Project Name	Complete 540 - TIP R-2721B		Date	Initial
Deliverable Type/Name	R-2721B Permit Drawings Review (S-012)		8/2/2019

**BUFFER DRAWING
SHEET 3 OF 19**

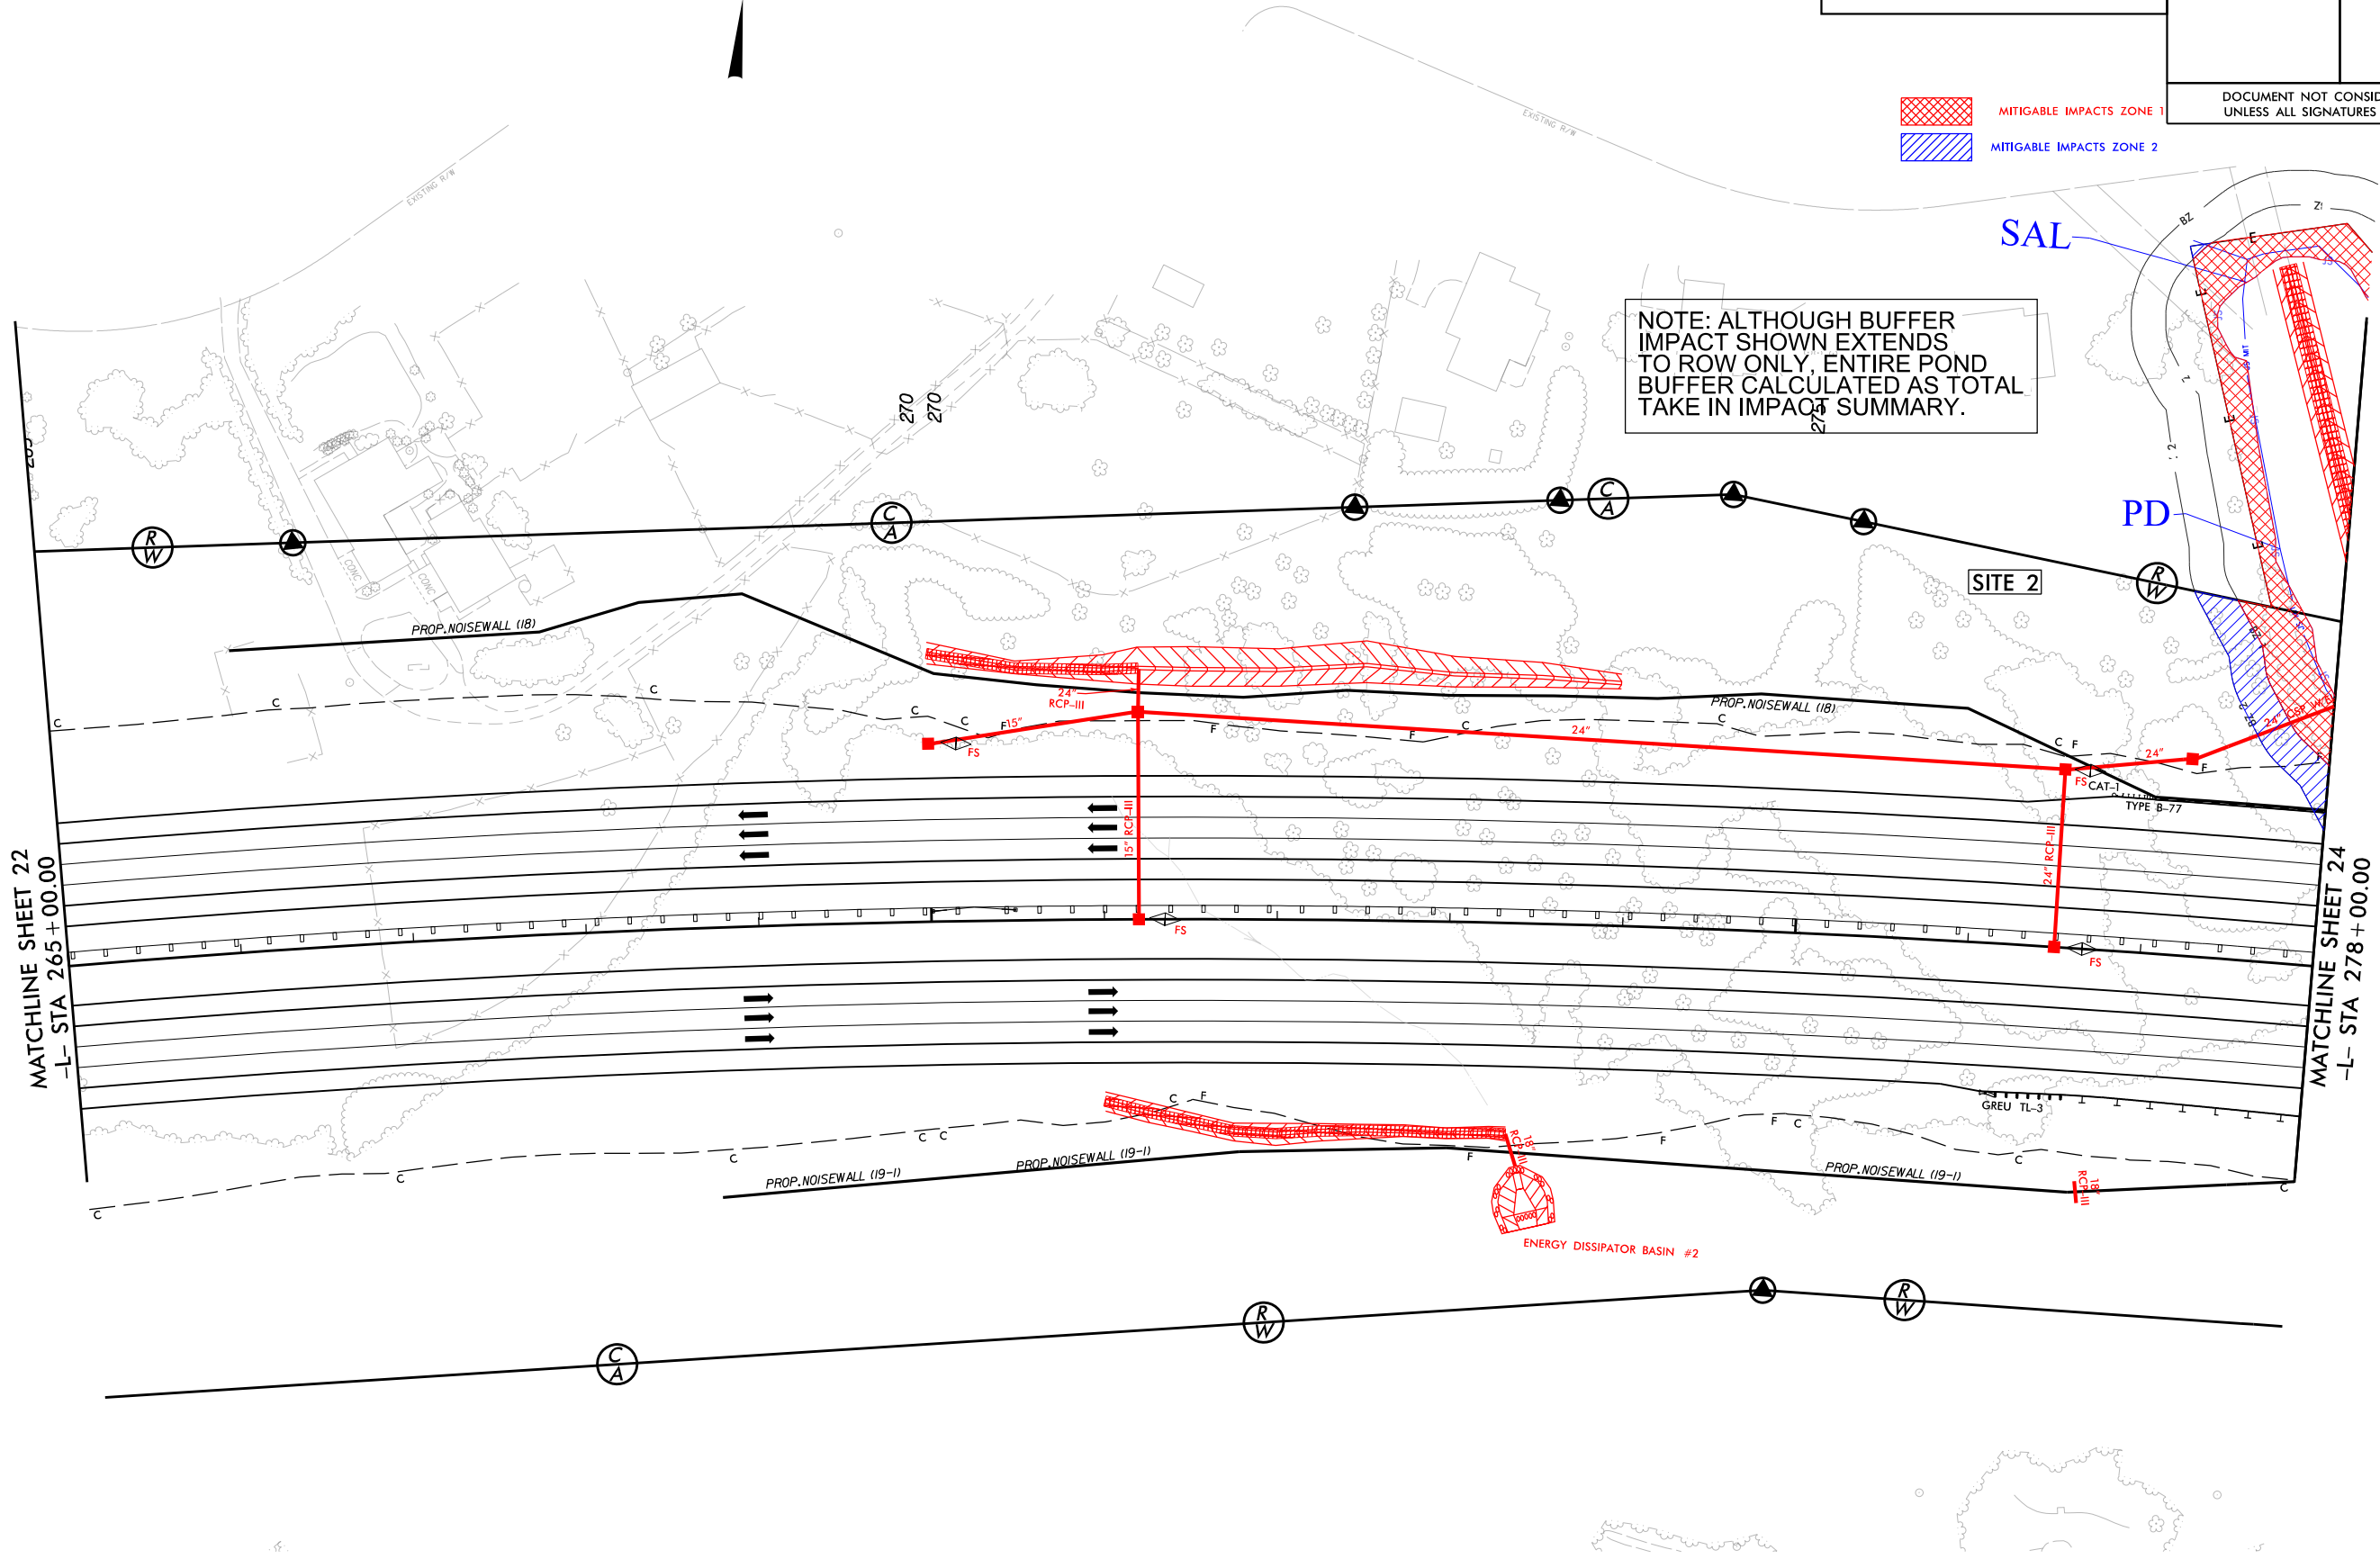
118	Permit drawing 67 of 69	65	HWM/NJT/MW	What is the easement for around Site 26? If for EC devices, the impact to the wetland will not be mechanized clearing	Noted. To be discussed with the Turnpike.		
119	Permit drawing 67 of 69	65	HWM/NJT/MW	Change the ditch callout labels to red	Removed labels due to a previous comment to eliminate clutter on the plans.		
120	Buffer Drawing 1 of 19	ALL	HWM/NJT/MW	Adjust Drawing sheets to say "Buffer Drawing" not "permit"	Updated		
121	General	ALL	HWM/NJT/MW	Match Buffer impact site numbers to wetland permit site numbers; if a surface water impact does not have an associated buffer impact, skip it in the buffer numbering	We have followed the previous permit application buffer sites since this is a modification.		
122	Buffer Drawing 1 of 19	1	HWM/NJT/MW	Add sheet numbers to overall plan view	Updated		
123	Buffer Drawing 3 of 19	23	HWM/NJT/MW	Remove duplicate station numbers	Updated

**BUFFER DRAWING
SHEET 4 OF 19**

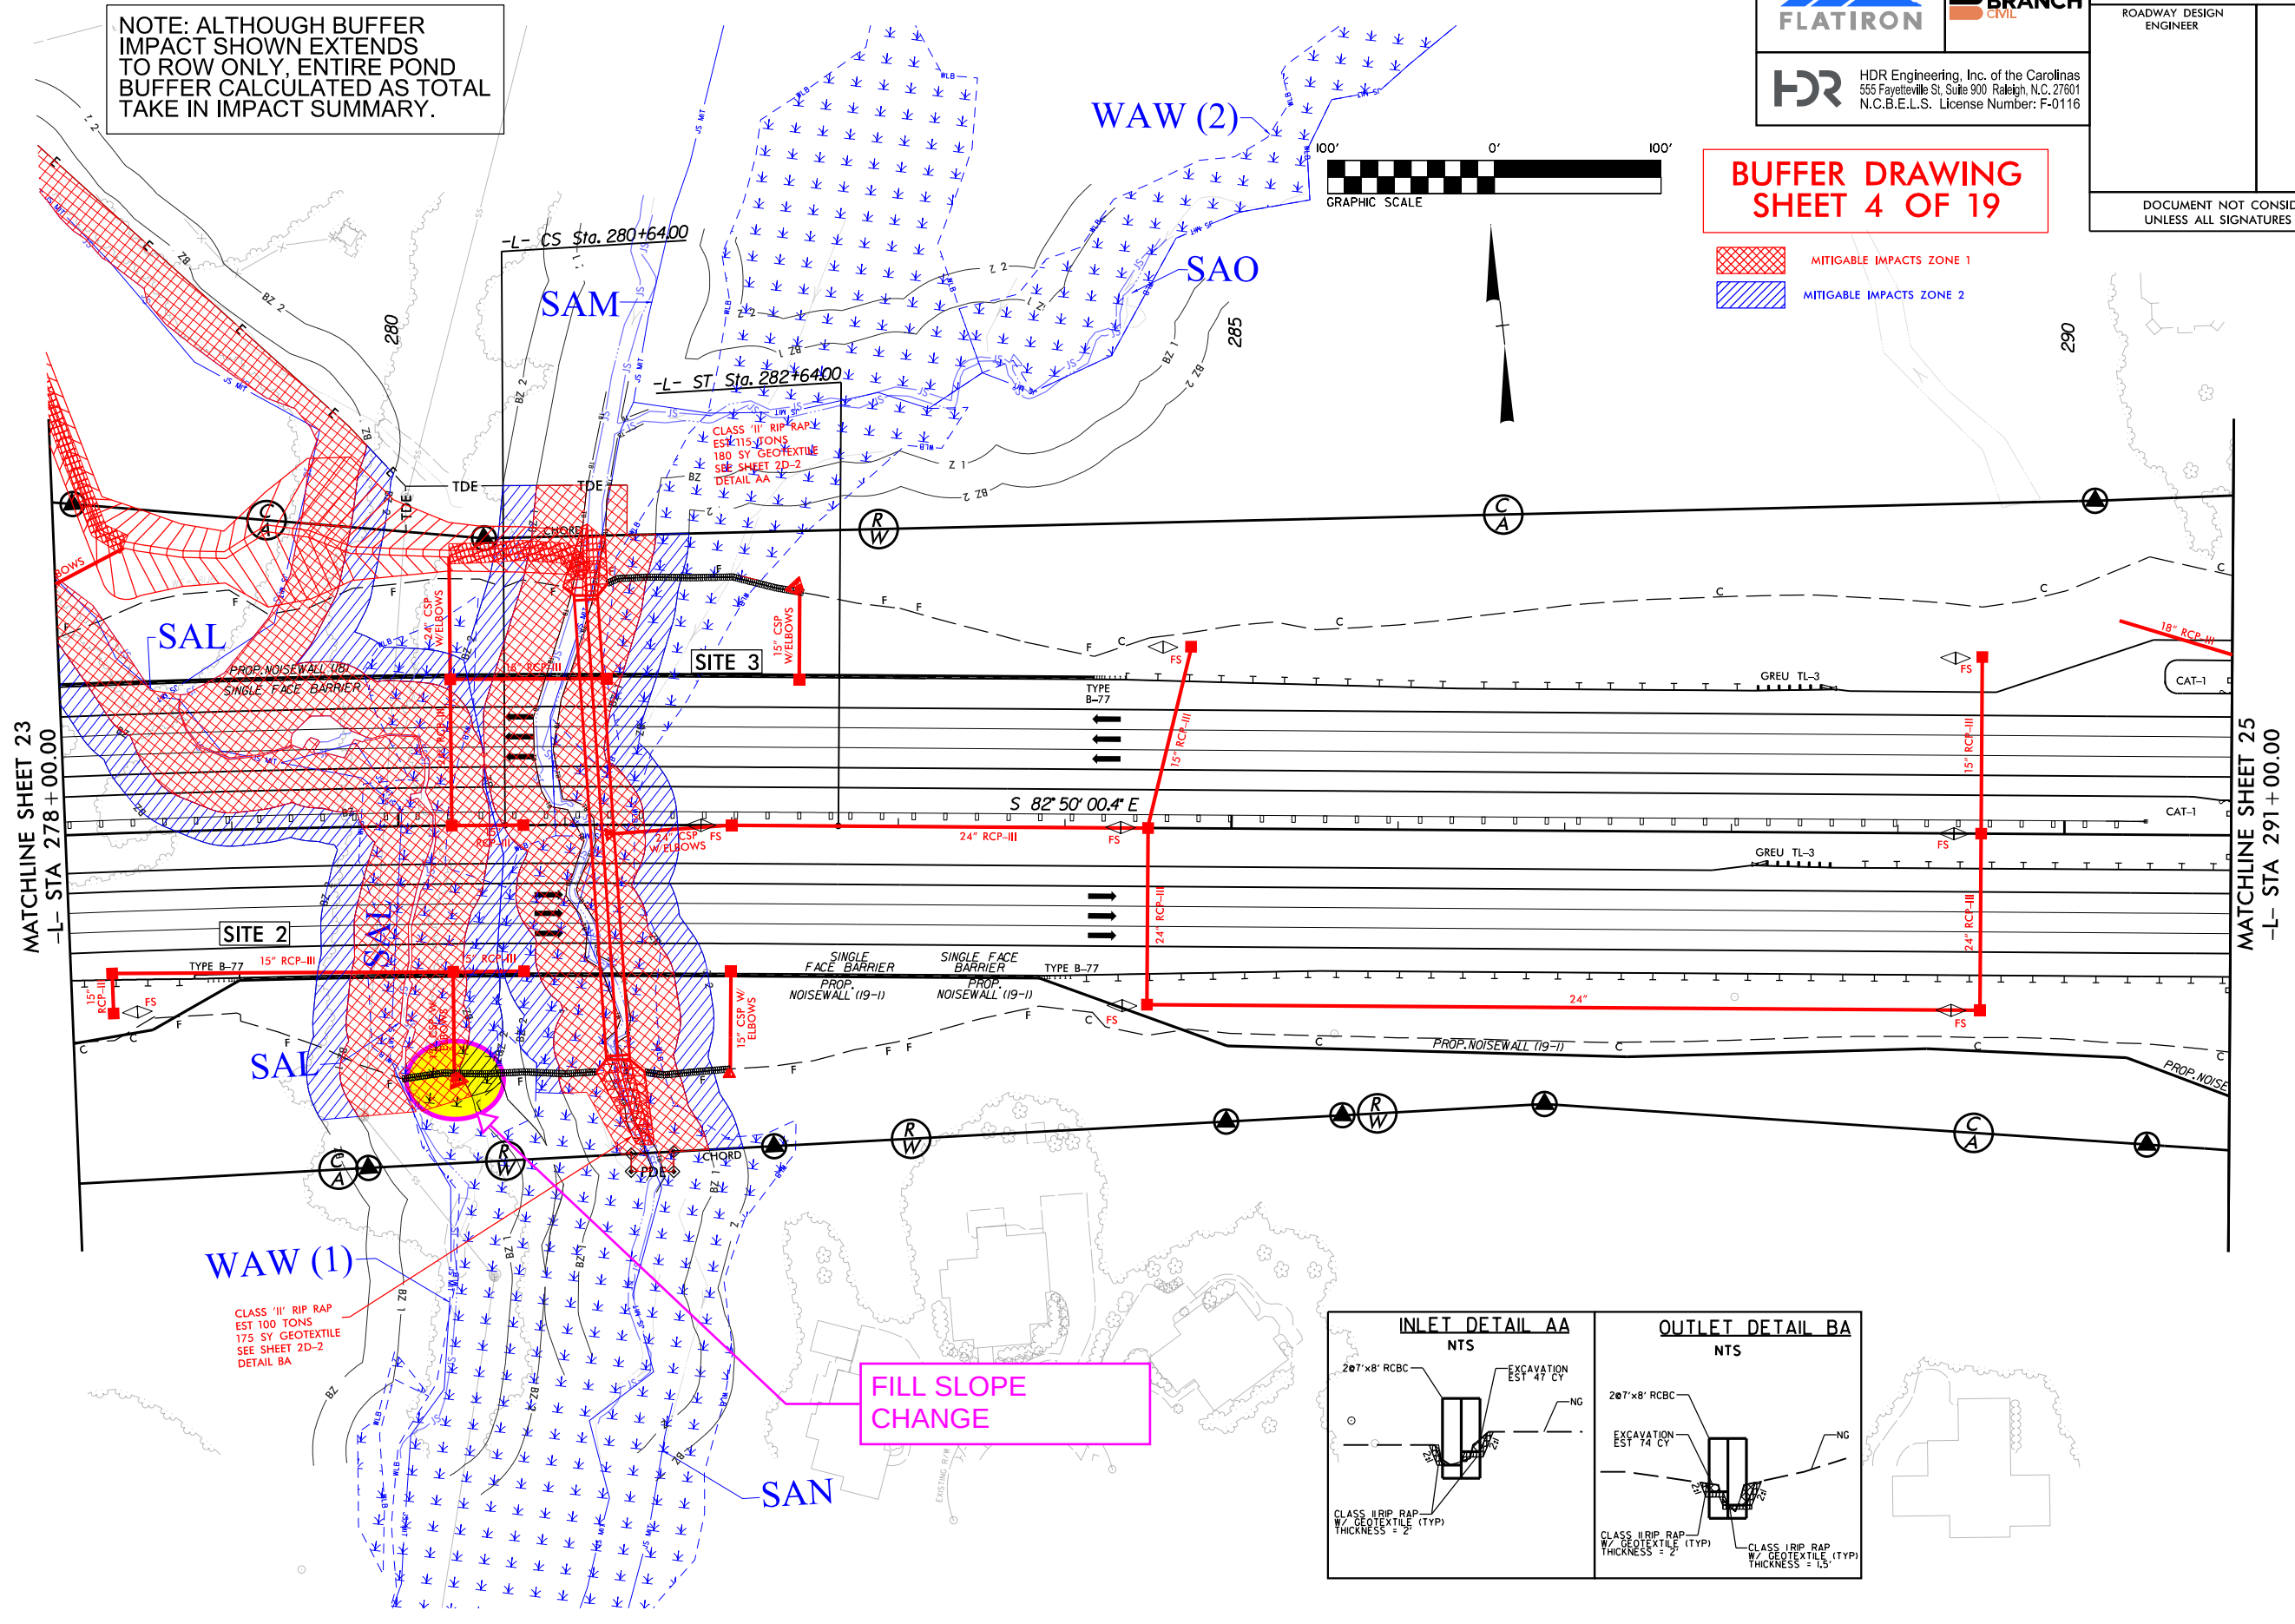
124	General	ALL	HWM/NJT/MW	Where pond buffers extend beyond the ROW, the plans currently show impacts to the entire buffer; however, the callout label states they are only shown to ROW but calculated in their entirety. Please adjust so the impacts are shown correctly	Updated		
125	Buffer drawing 4 of 19	24	HWM/NJT/MW	Utility impacts were originally proposed along stream SAM; account for buffer impacts appropriately and include a PUE where needed	Sewer line crosses NCDOT ROW at this location. Please refer to utility plans.		
126	Buffer drawing 4 of 19	24	HWM/NJT/MW	Buffer impacts extend beyond wetland impacts on south side; adjust so they match	Updated		
127	Buffer drawing 4 of 19	24	HWM/NJT/MW	Where is Buffer plan sheet 8? Rip rap pad in buffer at STA 295+00	Included		
128	Buffer drawing 10 of 19	31	HWM/NJT/MW	Label inset	Updated		
129	Buffer drawing 10 of 19	31	HWM/NJT/MW	In inset, adjust buffer hatching color to match plan sheet	Updated
